**Consultation Response from KC,
Lead Local Flood Authority**

**2026/90740 Part of former St Luke's Hospital site, Blackmoorfoot Road, Crosland Moor,
Huddersfield, HD4 5RA**

Date Responded: 17th April 2026

Drawing title **Temporary Drainage**

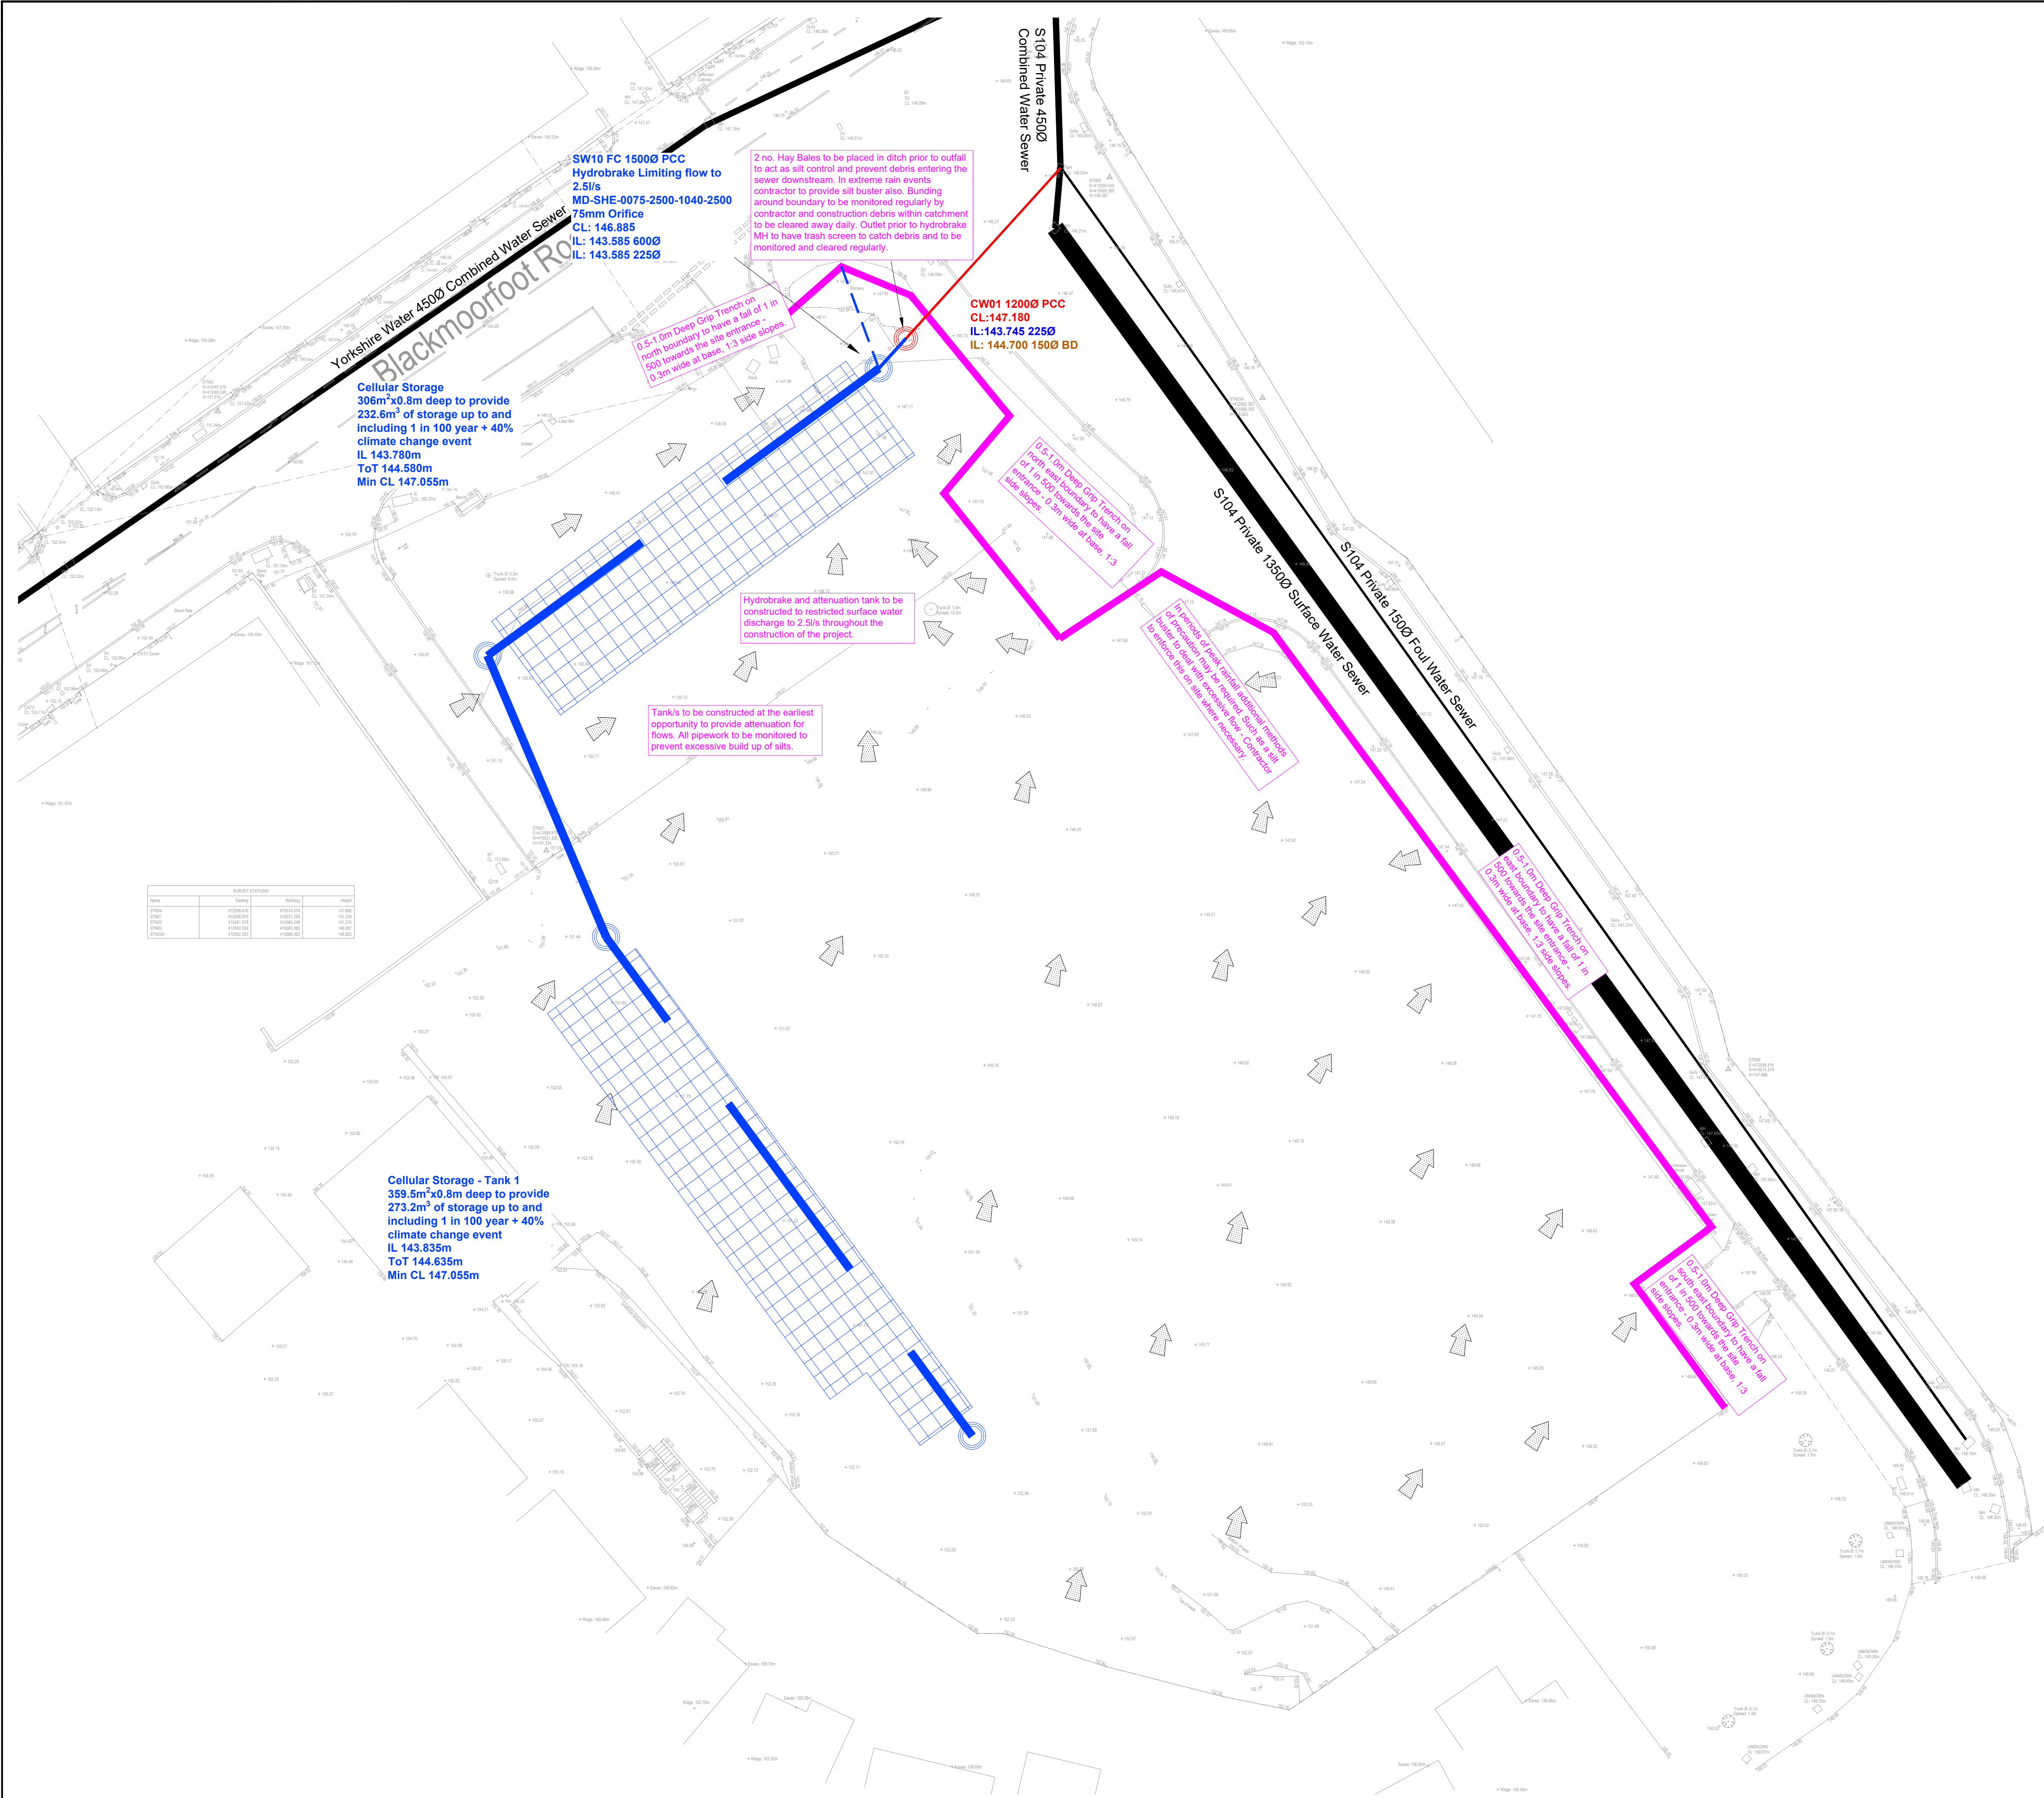
In respect of original flood risk and drainage conditions, the temporary drainage plan is acceptable as proportionate to the risk identified and the scale of development (Condition 9)

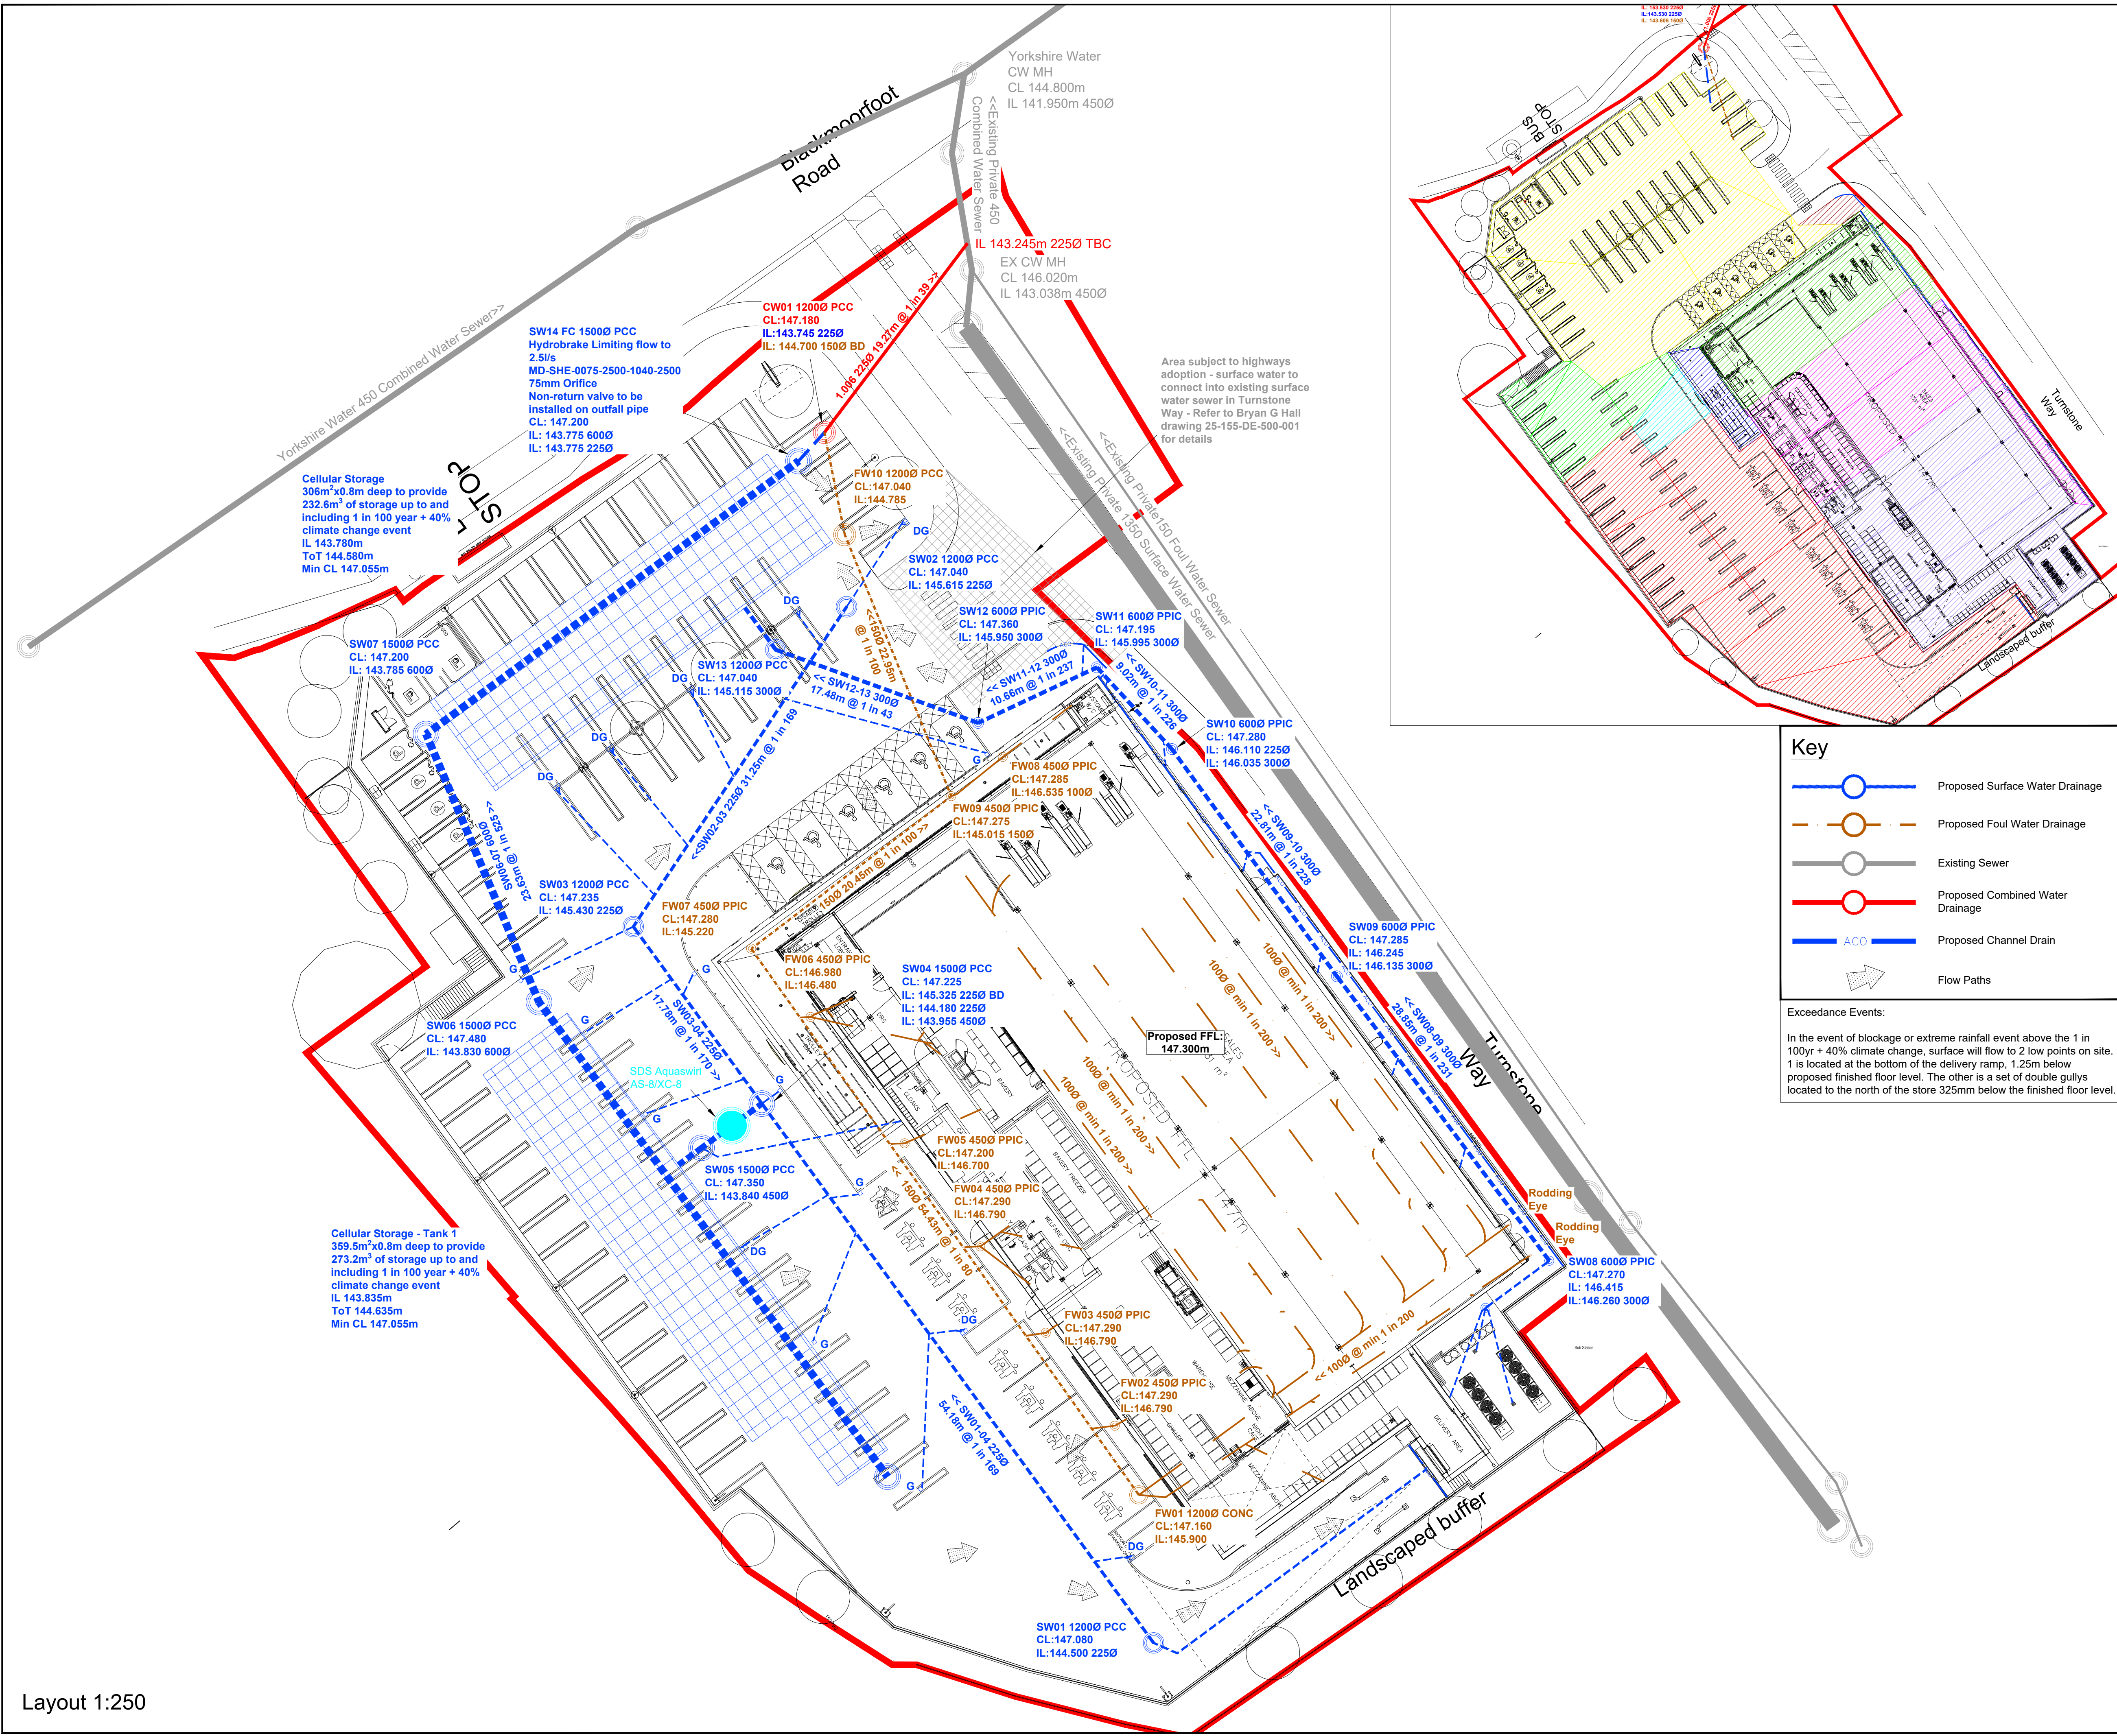
An accepted drainage scheme has been submitted that includes a maintenance and management plan. The non return valve inclusion to protect crate storage from any surcharge from the existing public combined sewer is noted. (Condition 16)

Client	LiDL		
Project	LiDL Blackmoorfoot Rd Huddersfield		
Drawing title	Proposed Levels		
Drawn	CG	Chkd	PB
Sheet Size	A1	Drawing No.	21561-DR-C-0110
		Date	November 2025
		Scale	1:200
		Revision	P06

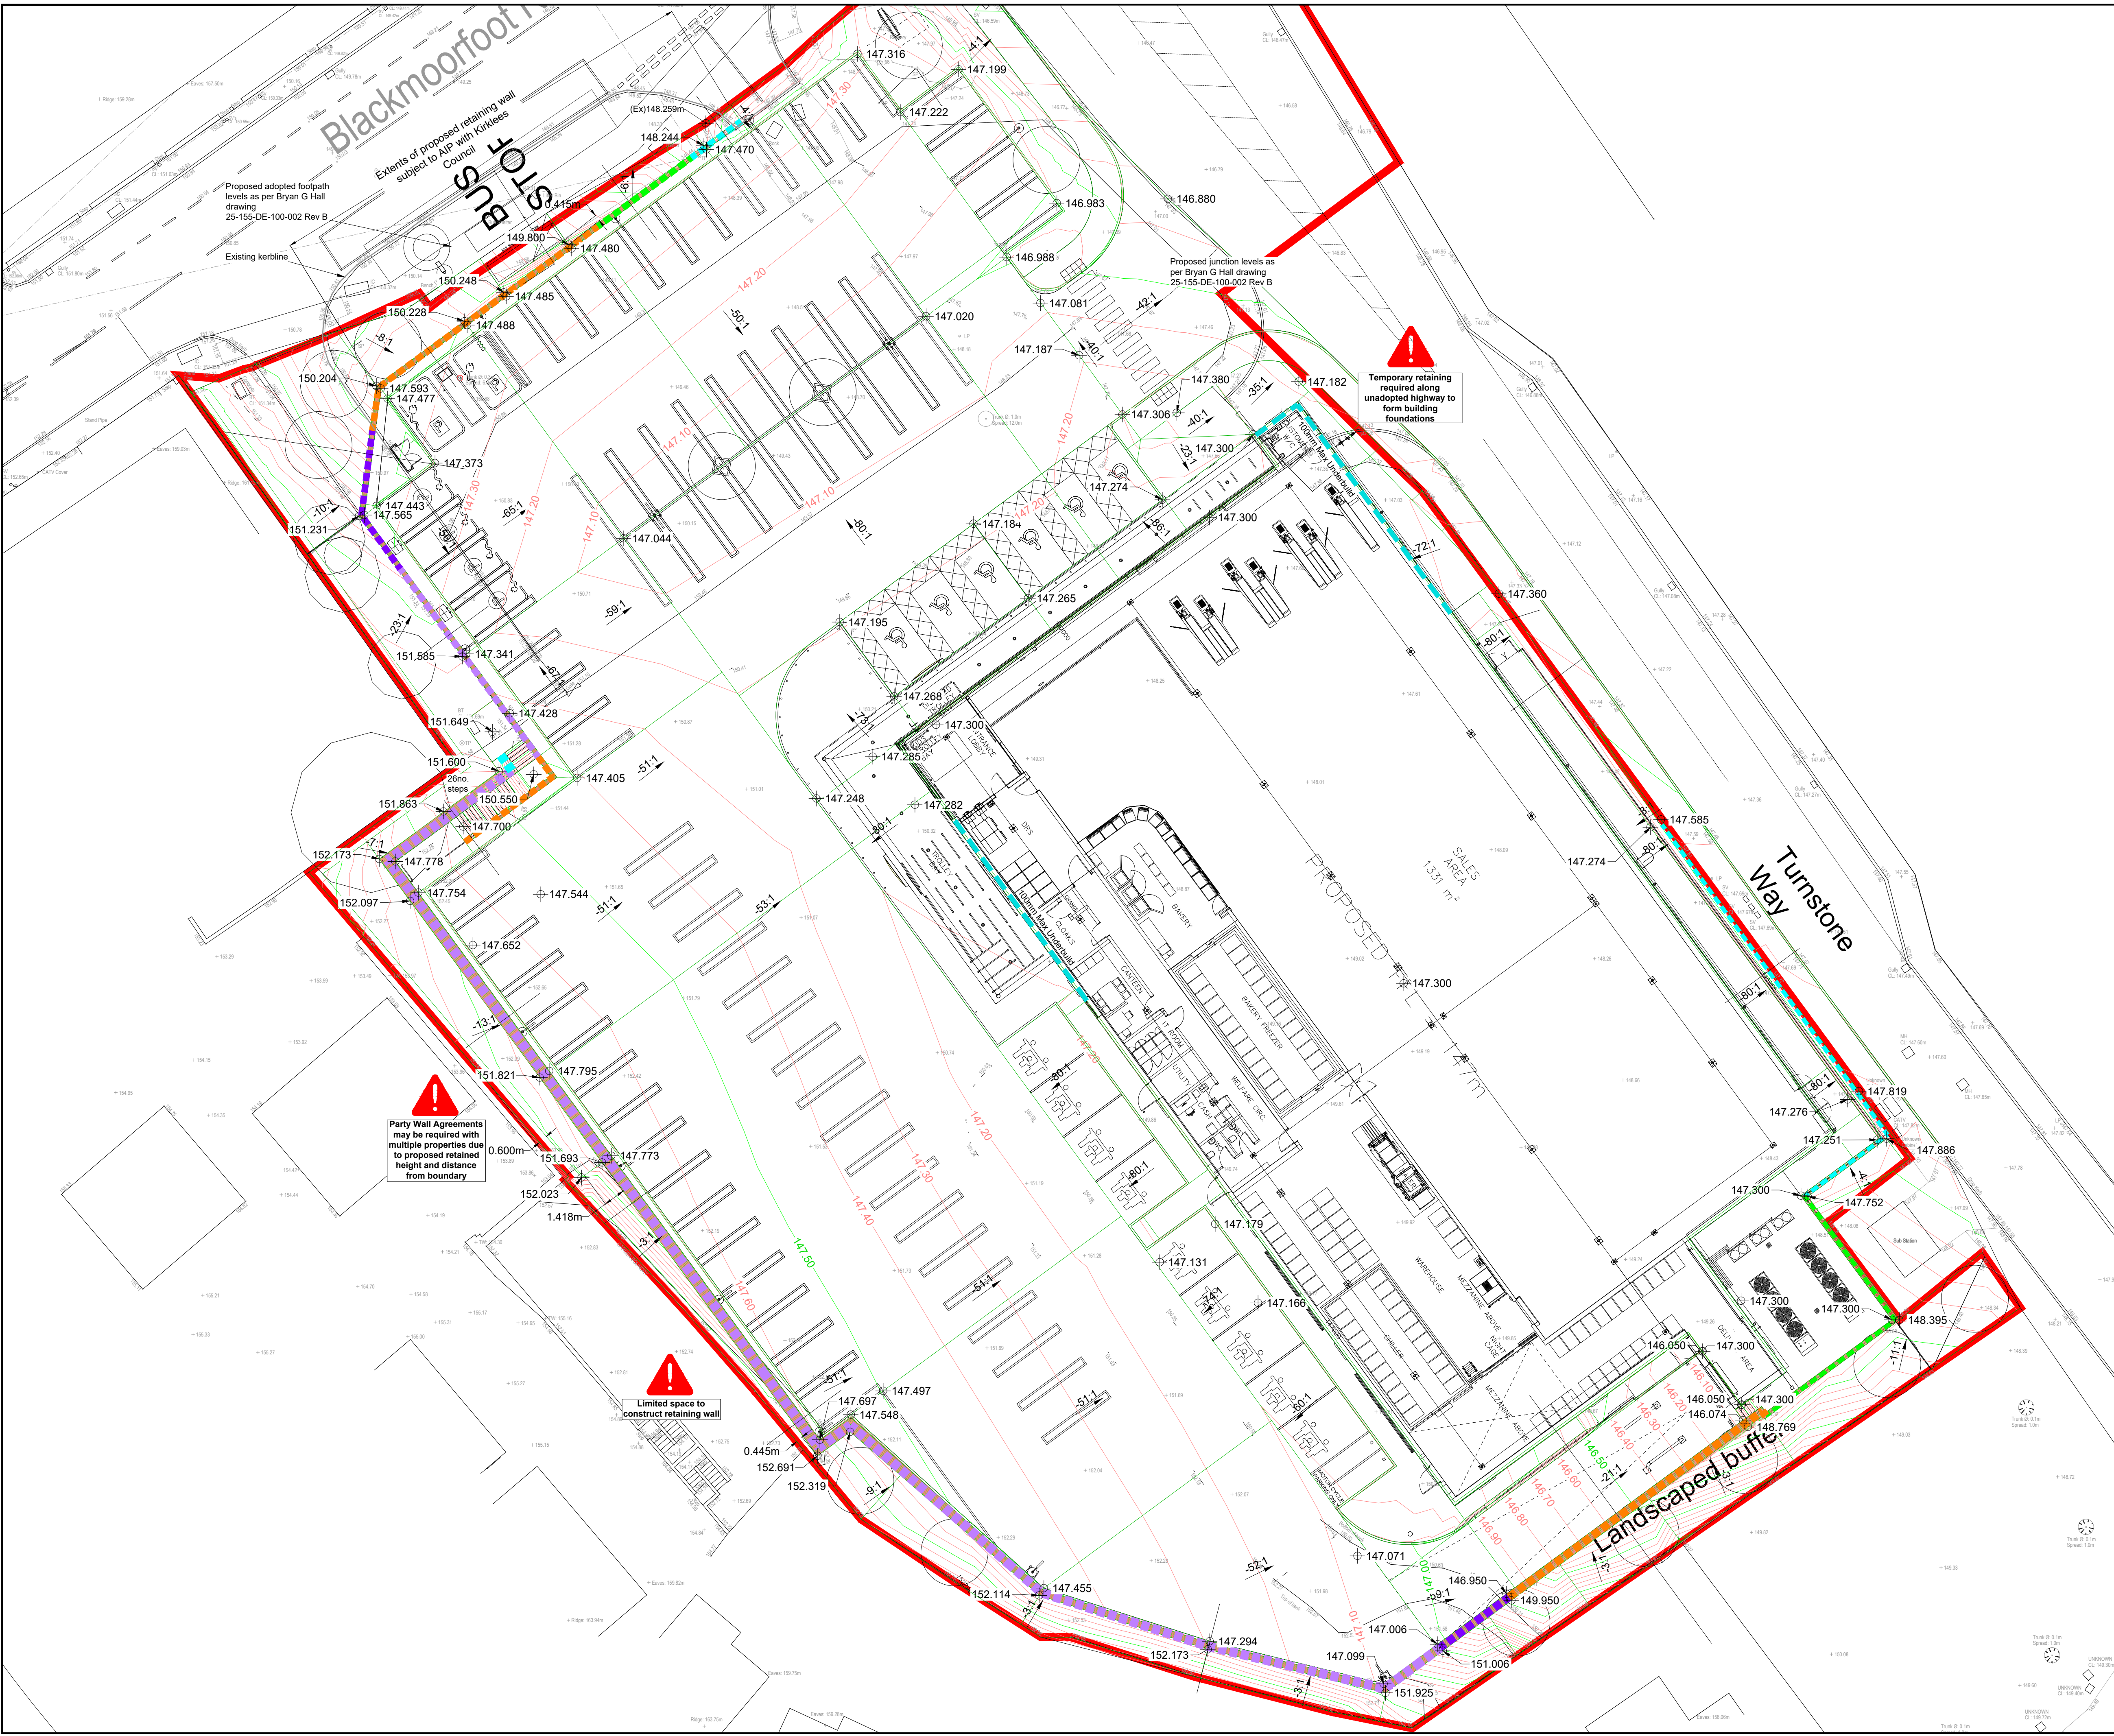
Clarification on flood routing has been provided by levels and gradients shown on submitted plans. This is now accepted (Condition 15)
